PROJECT NAME: **Wagon Wheel Plat Amendment (LP-14-00001)**

STAFF REPORT

Wagon Wheel Plat Amendment (LP-14-00001)

TO: Kittitas County Hearing Examiner
FROM: Kittitas County Community Development Services Staff
RE: Wagon Wheel Plat Amendment (LP-14-00001)
DATE: July 23, 2015 (Hearing Date)

**ADJUSTED AREAS OF PARCELS IMPACTED BY ROAD VACATION & RELOCATION**

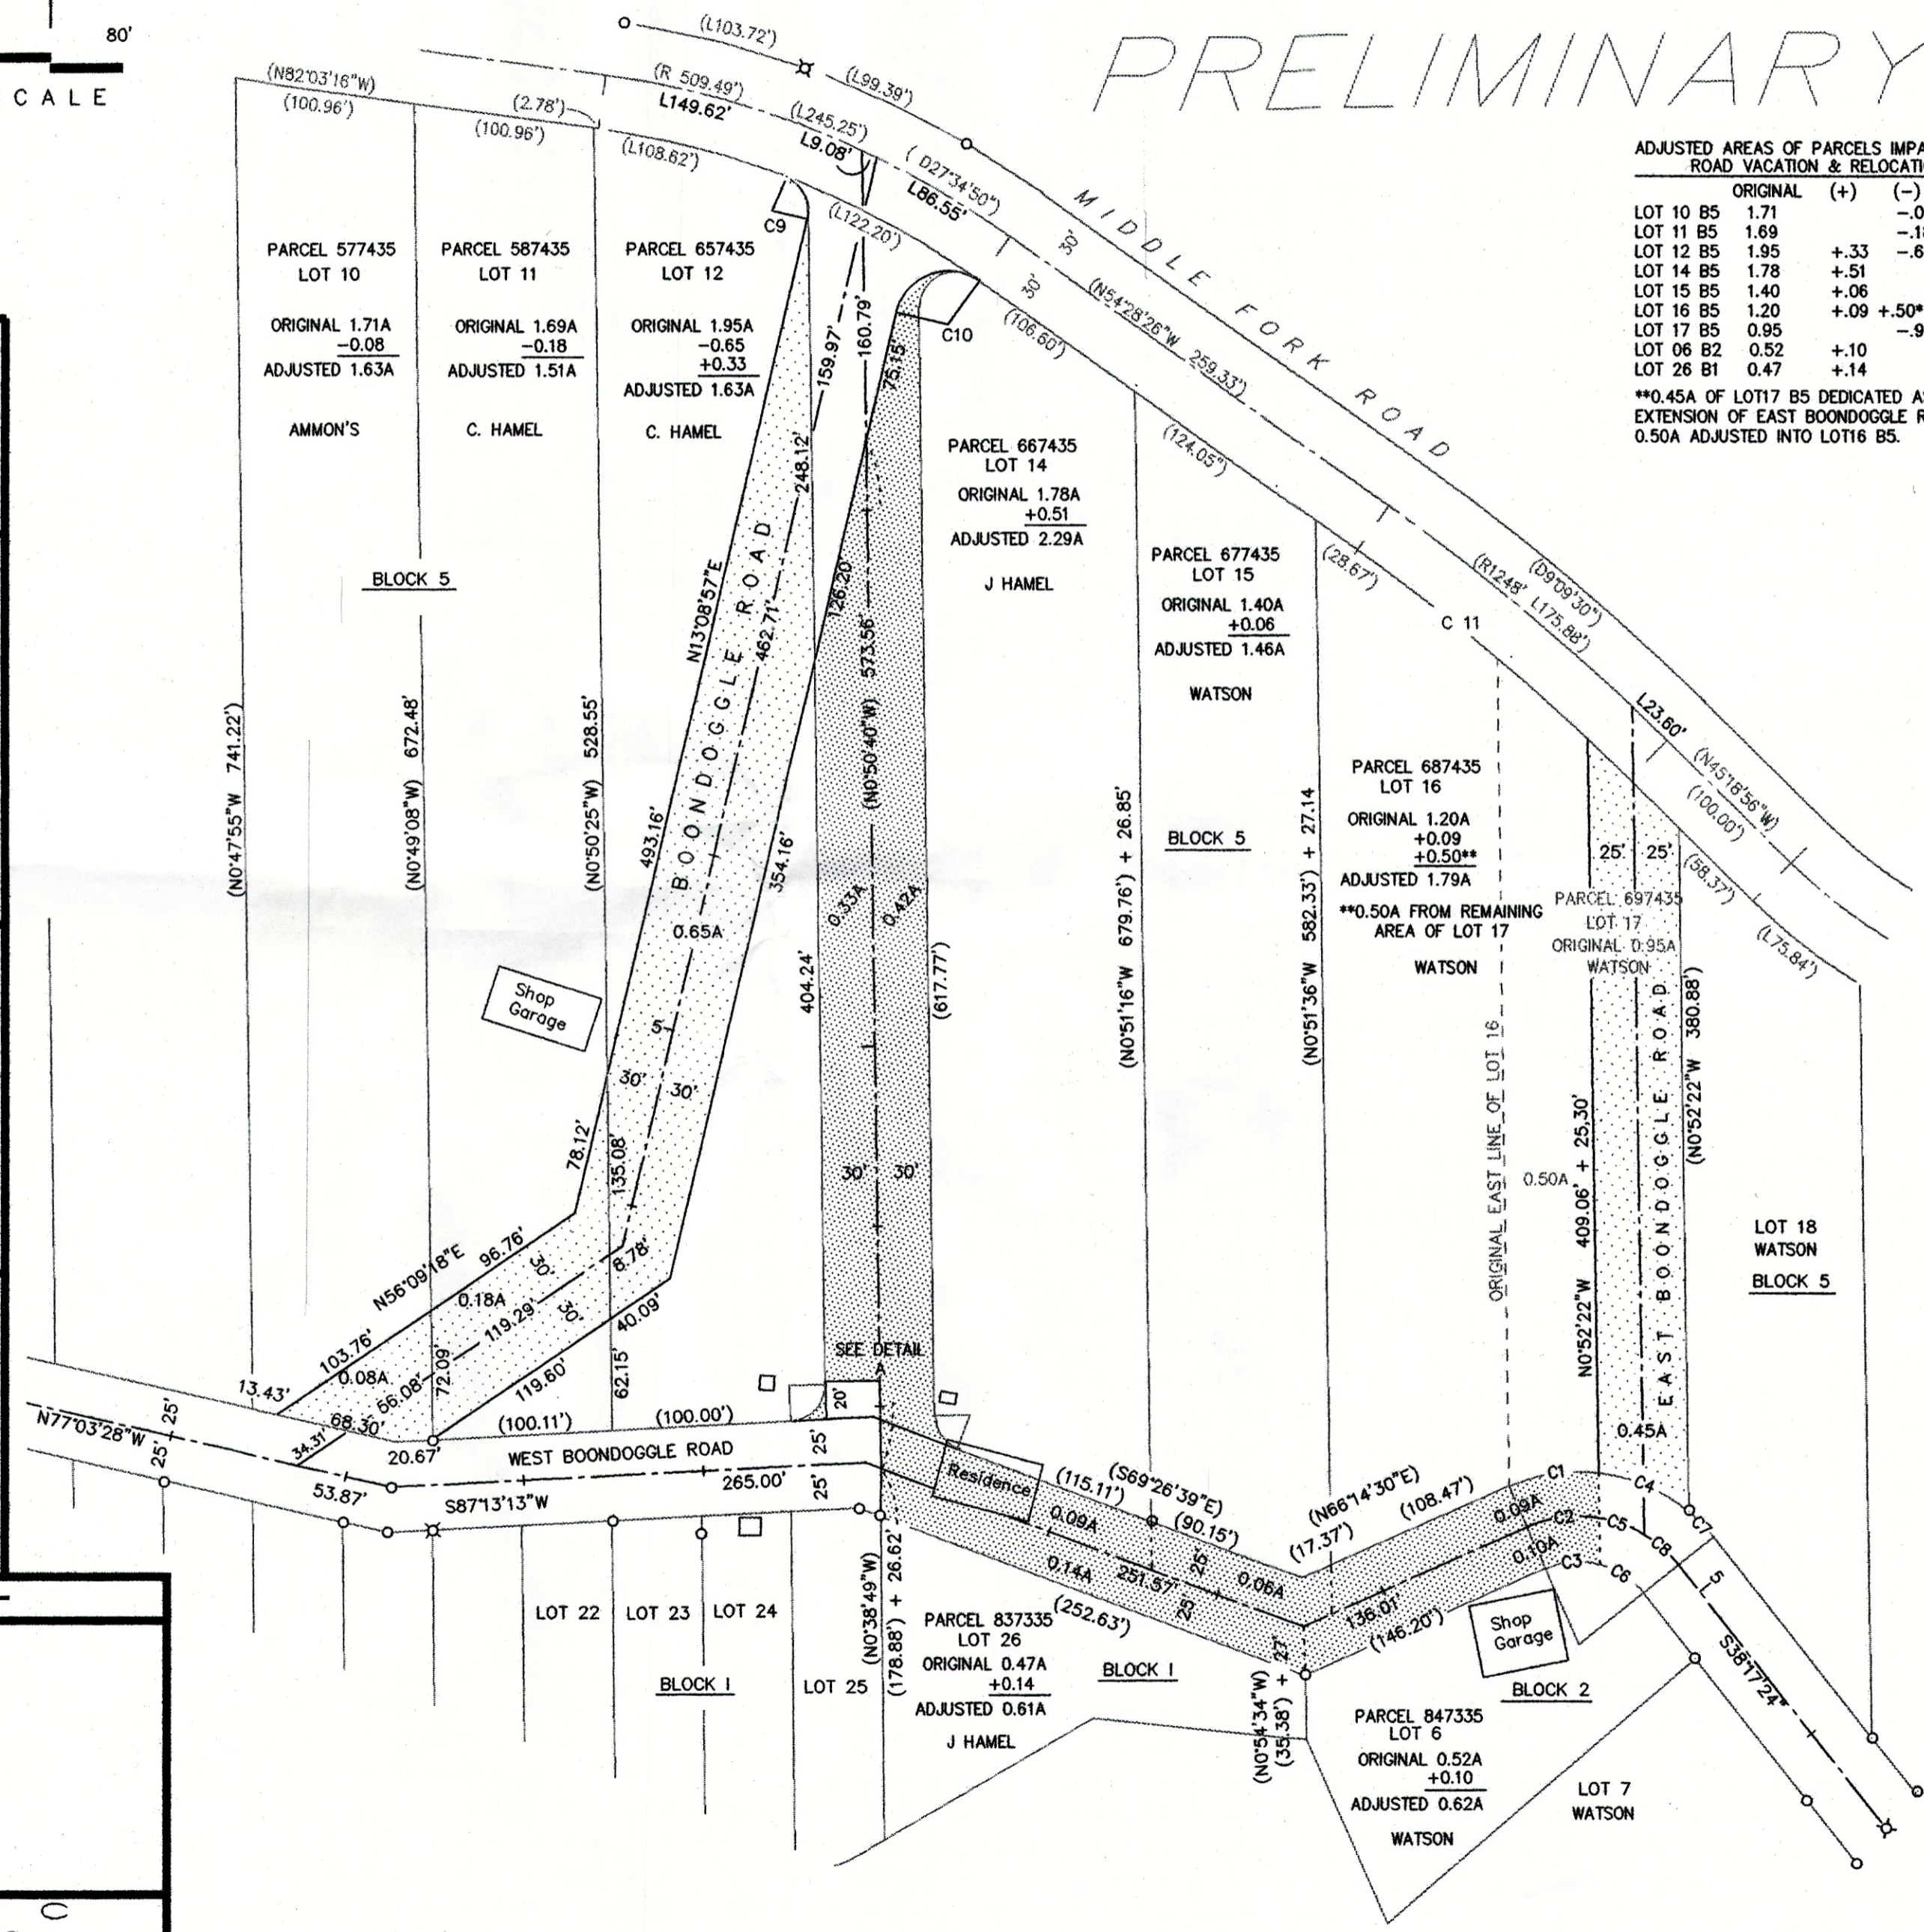
The current configurations of the lots are considered legal-nonconforming. The proposed plat amendment to Lots 10, 11 & 12 makes these lots more nonconforming. Therefore this application is inconsistent with current County Codes. Specifically this project proposes to reduce the size of three (3) lots: Lot 10 from 1.71 acres to 1.63 acres, Lot 11 from 1.69 acres to 1.51 acres and Lot 12 from 1.95 acres to 1.63 acres. The forest and range zone is a 20 acre minimum. The existing lots are legal nonconforming by allowing this amendment we would be creating more nonconforming lots.

1. Kittitas County KCC Title 16 Subdivisions states that no lot within the county can become more nonconforming. This includes lots that are already nonconforming parcels. From this staff concludes that the Wagon Wheel Plat Amendment must be denied based upon the fact that three (3) of the subject parcels are becoming more nonconforming.
